**From:** Harry Chalk  
**Sent:** 15 April 2025 12:36  
**To:** Planning.Responses  
**Subject:** FW: RE: RE: RE: 31 Aldwick Road BR/32/25/PL  
**Attachments:** 4090\_01\_06.pdf; Action Sheet v4 Electronic Version.docx

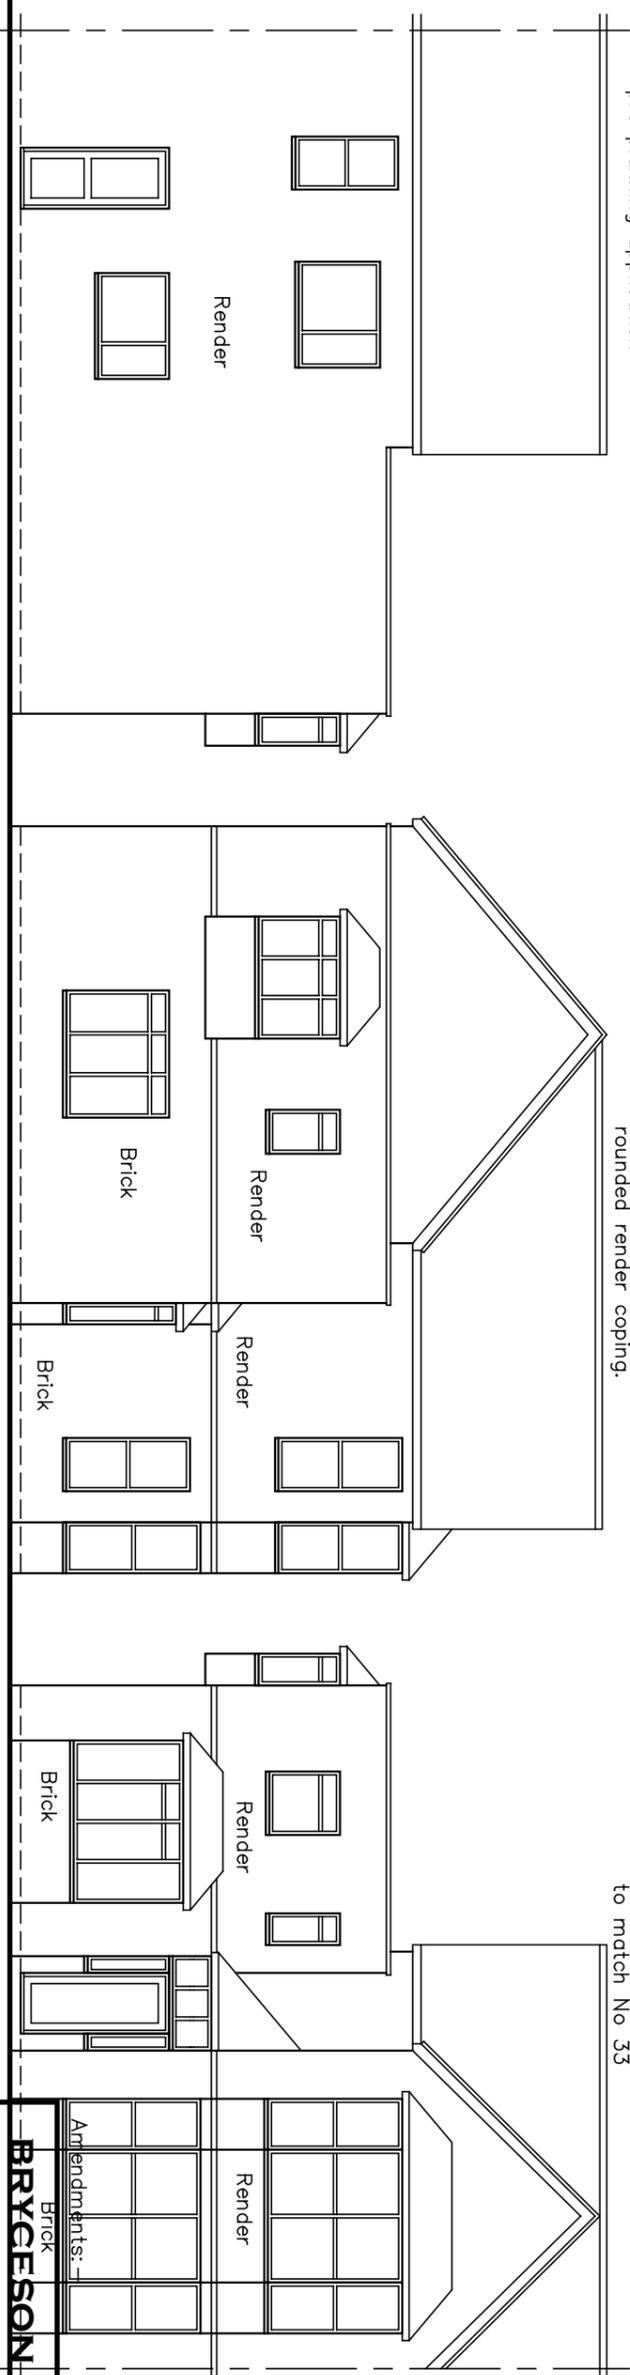
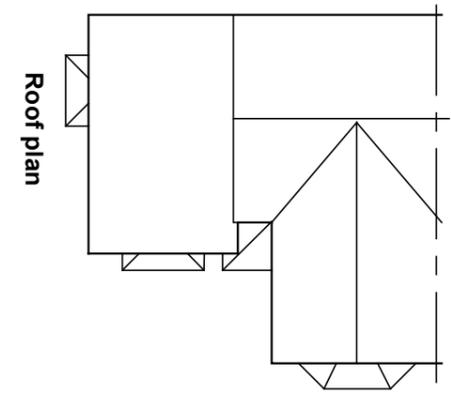
Thanks for amending so swiftly. For clarity, is the low front boundary wall to simply be removed and rebuilt to match the neighbouring front boundary wall? It appears to currently remain in situ and matching the neighbours wall (see attached).

Could I ask that the plans/elevations be amended to reflect this please?  
Could I also ask that the proposed elevations be annotated to show where the brickwork and render will remain following the repairs? I understand this will match the existing elevations, but it would be helpful for context.

Following review of the Conservation Officer comments, and those from the CAAP, with respects to rebuilding the wall in flint, could you confirm that the applicant would be happy to rebuild the wall with individual flints rather than flint blocks?

I think this precise now, to repair the rendered brick front wall to match 33.

See revised attached. The side wall is now flint and the front wall rendered brick matching No. 33.

Yes the applicant is happy to use individual flints.
